File No: NTH24/00543/001

RE: Review of Environmental Impact Statement (SSD-70748466) - Advice on EIS - Huntlee New Town - Stage 2 - Wine Country Drive Rothbury

TfNSW has reviewed the referred information and provides the following comments to assist the consent authority:

WCD-C04.01

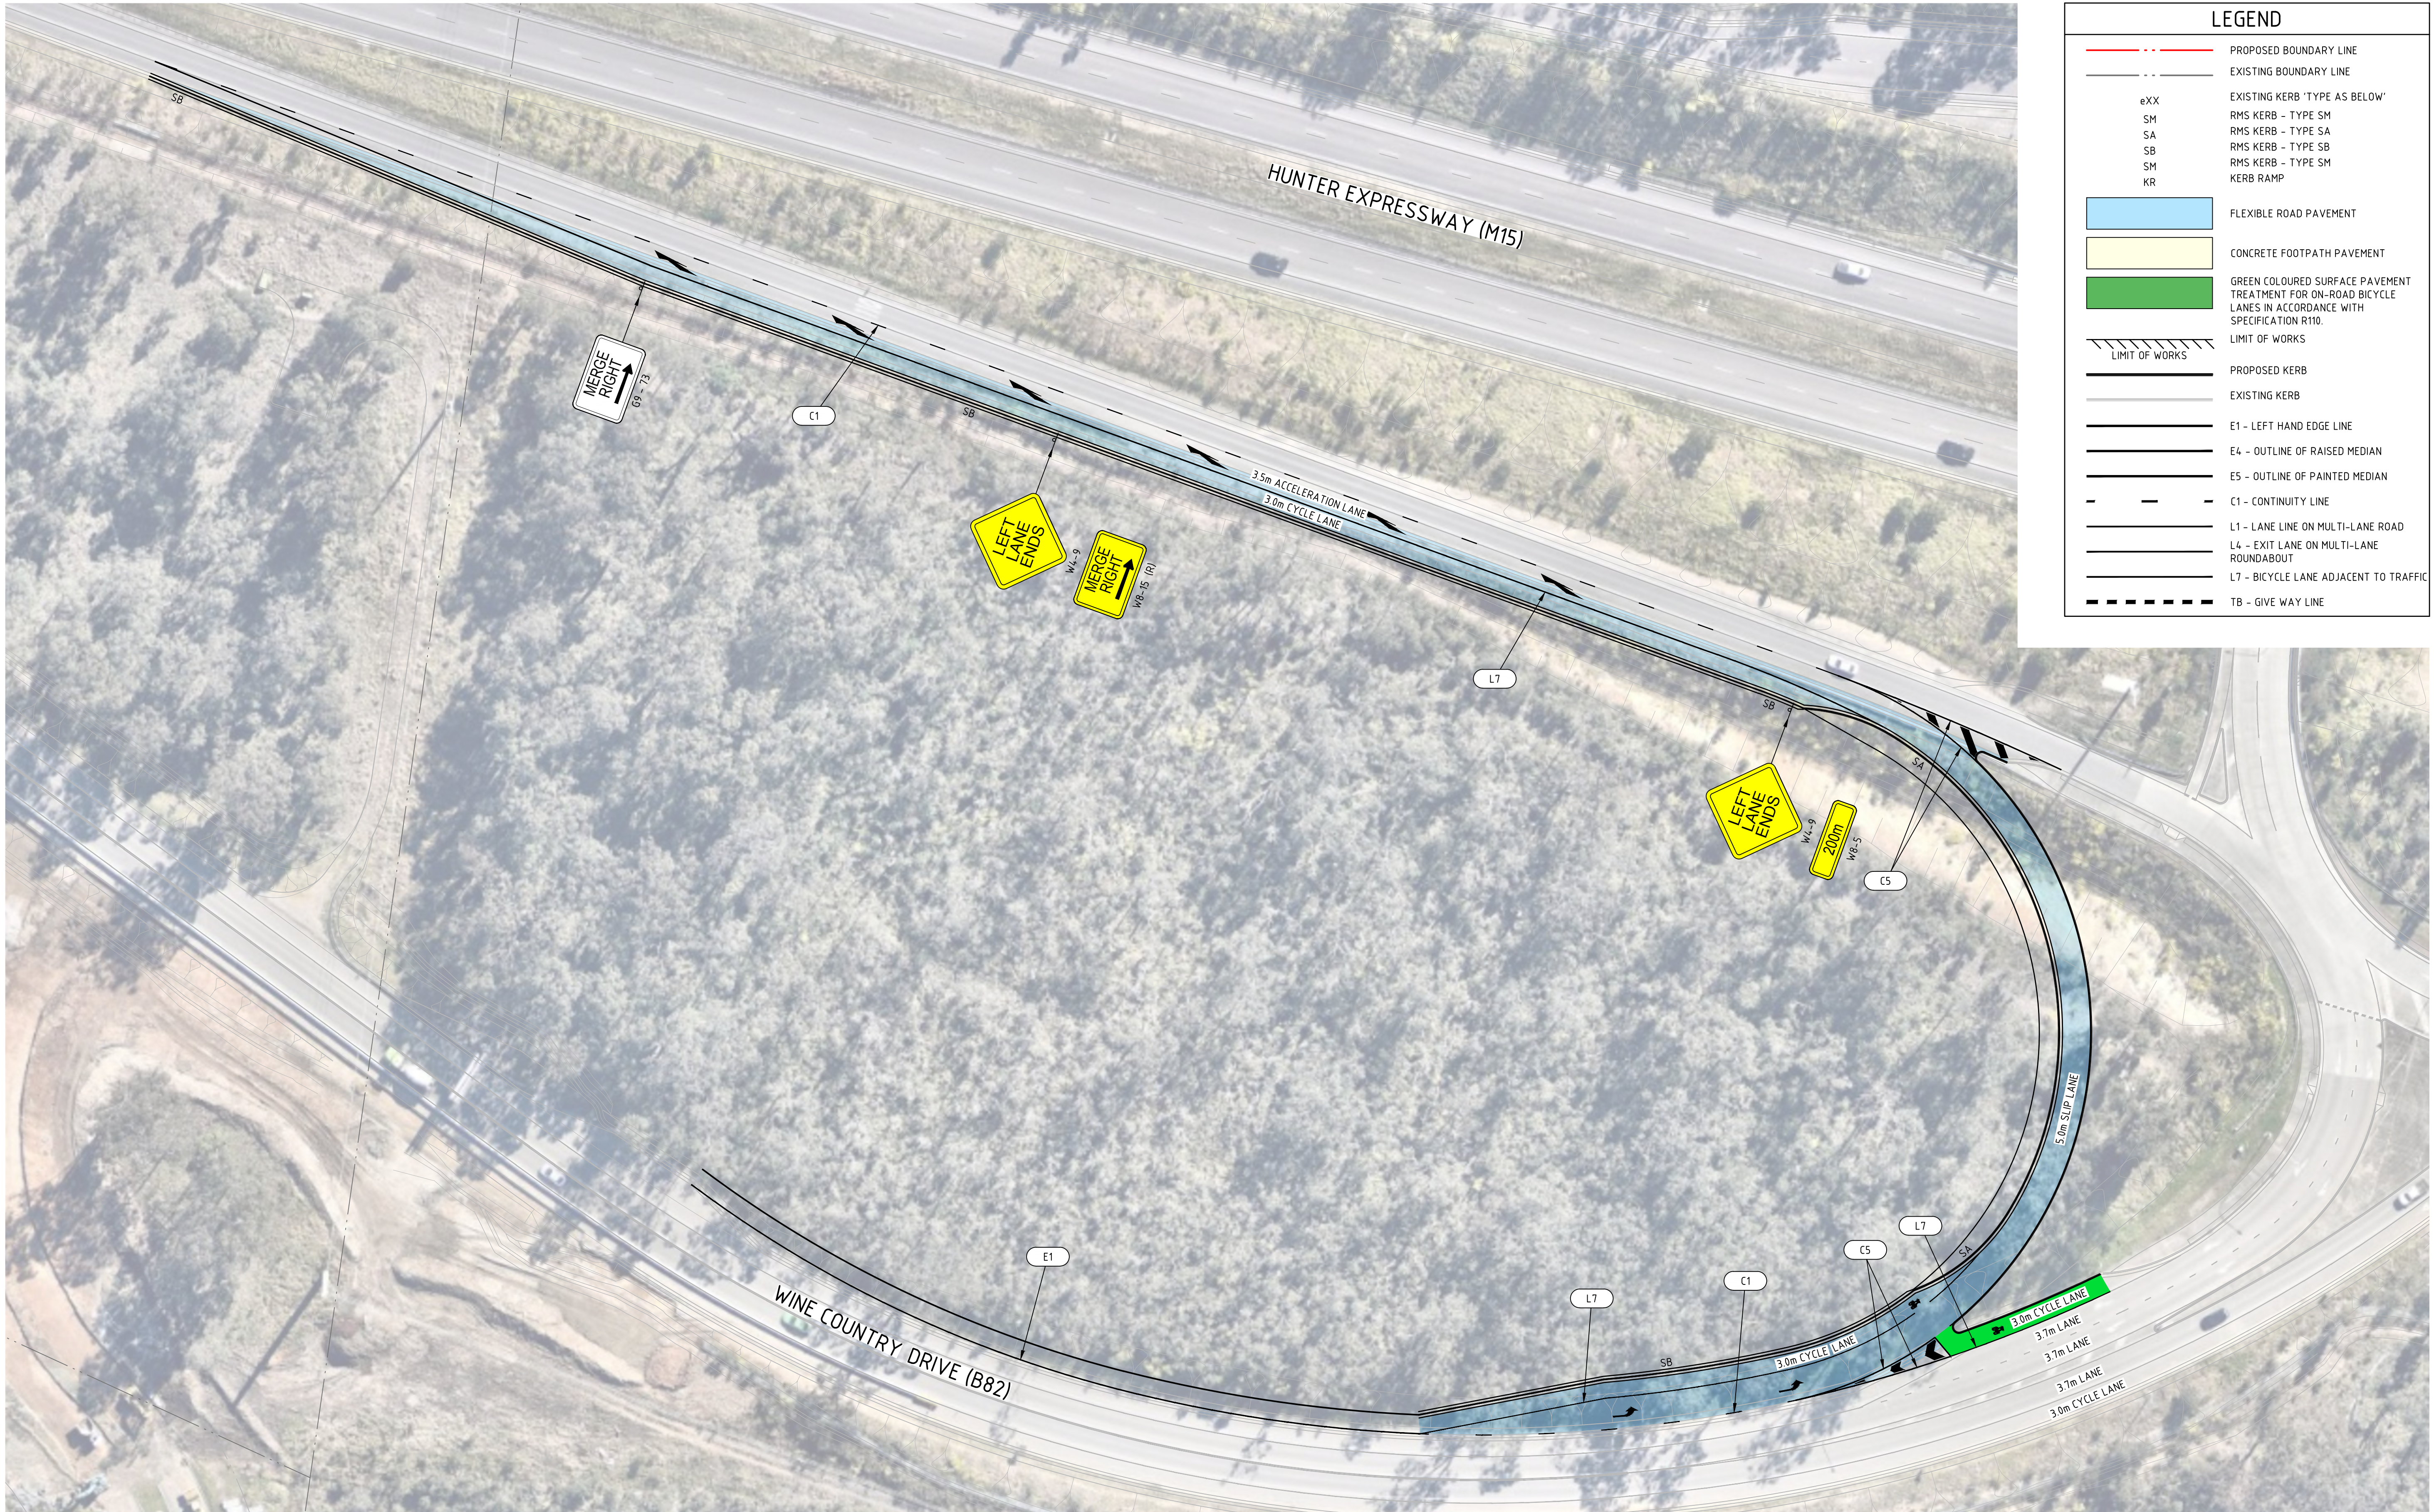
- Road Design (A-11)
 - Please show the current WAD for the slip lane, TCS and duplication on the current drawing set.
 - No pavement arrows are shown to illustrate the intended double right turn.

- The additional lane and merge on the ramp are inconsistent with recommendations from AGRD part 4C section 11.3.3 and table 11.2.
 - Runout area in accordance with AGRD is required at the end of merges where the shoulder is less than 2.5m

- Where the new slip lane joins the existing westbound highway entry ramp, the raised island nose should run parallel for 10m after the tangent to force a parallel merge in accordance with AGRD 4a figure 8.7. In this area, a space is also required for cyclist to cross with care. See image below titled 'Figure 8:7 Rural CHL treatment with an acceleration lane'.

- Cams may be required on the new roundabout slip lane.
- The start of the roundabout slip lane is less than the minimum diverge length required for the design speed.
- Can the start of the left turn slip lane be seen at the design speed on the inside of the curve?

DRAWING TITLE
CONCEPT CIVIL
ENGINEERING PACKAGE
INTERSECTION A-3 - CIVIL WORKS
PLAN

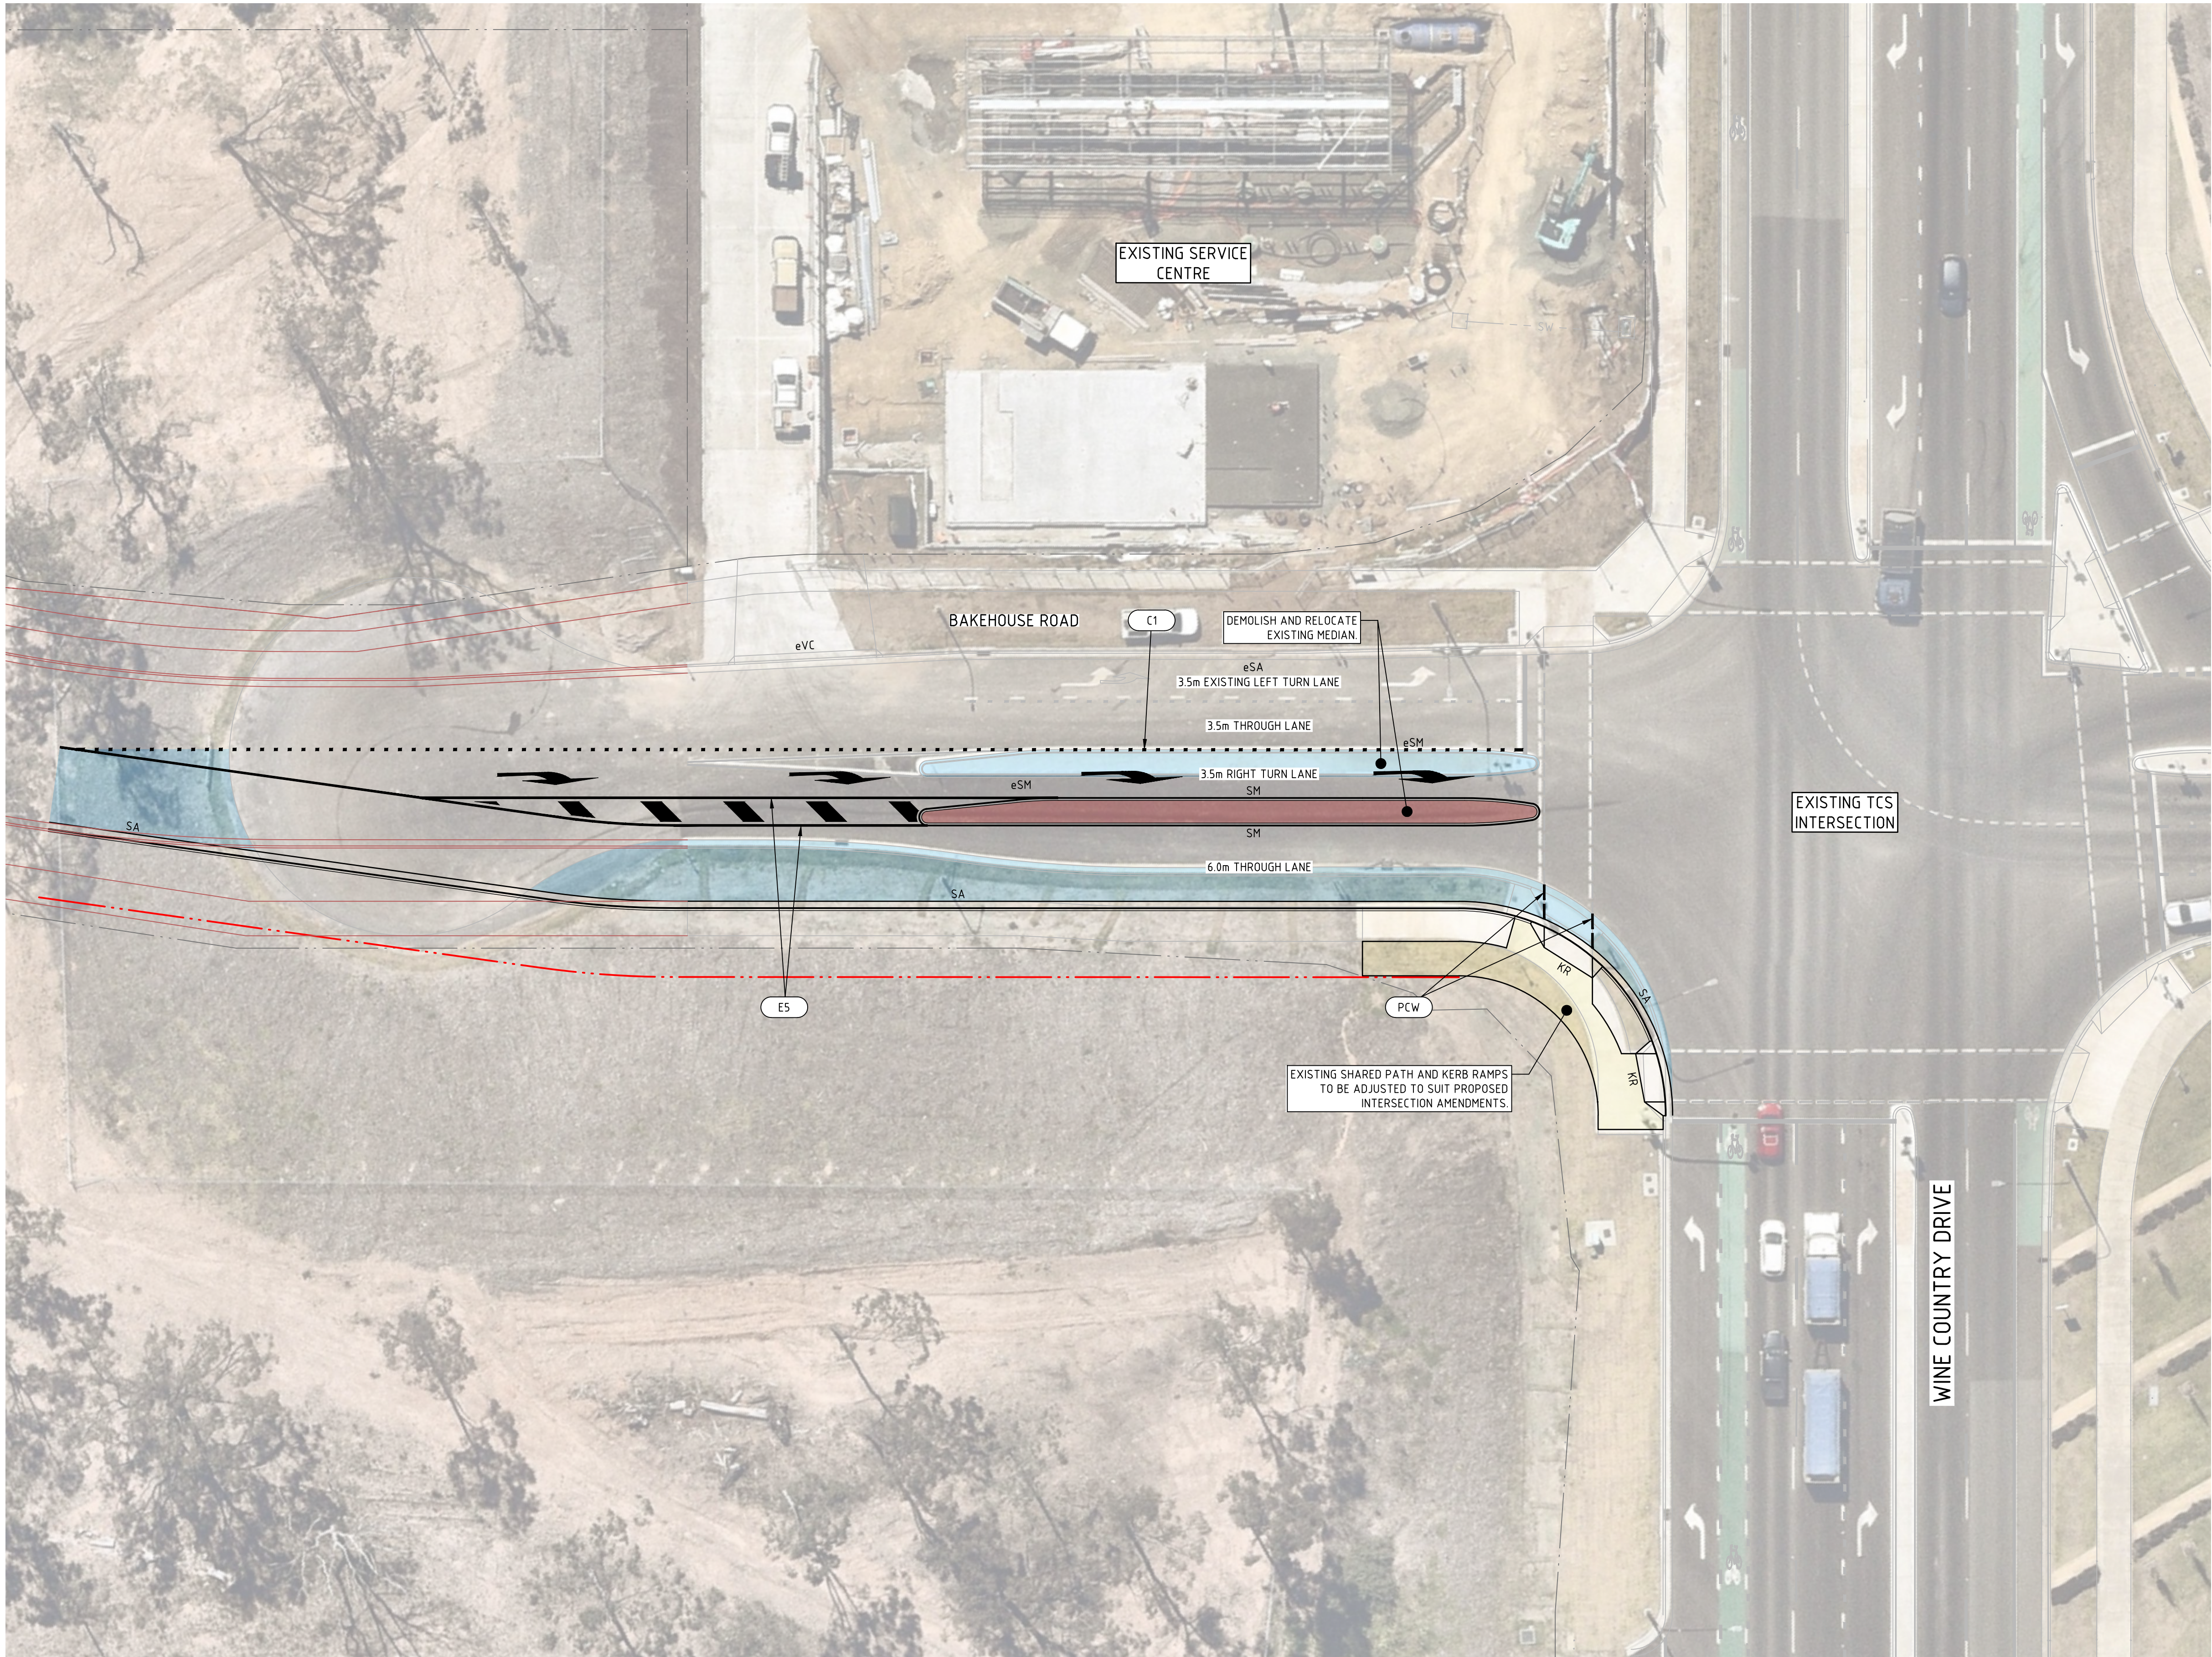
- Further upgrades are identified as part of Stage 2 Phase 2 at intersections A-3, A-5 & A-8. DPHI confirmation is sought as to how these are to be considered with this
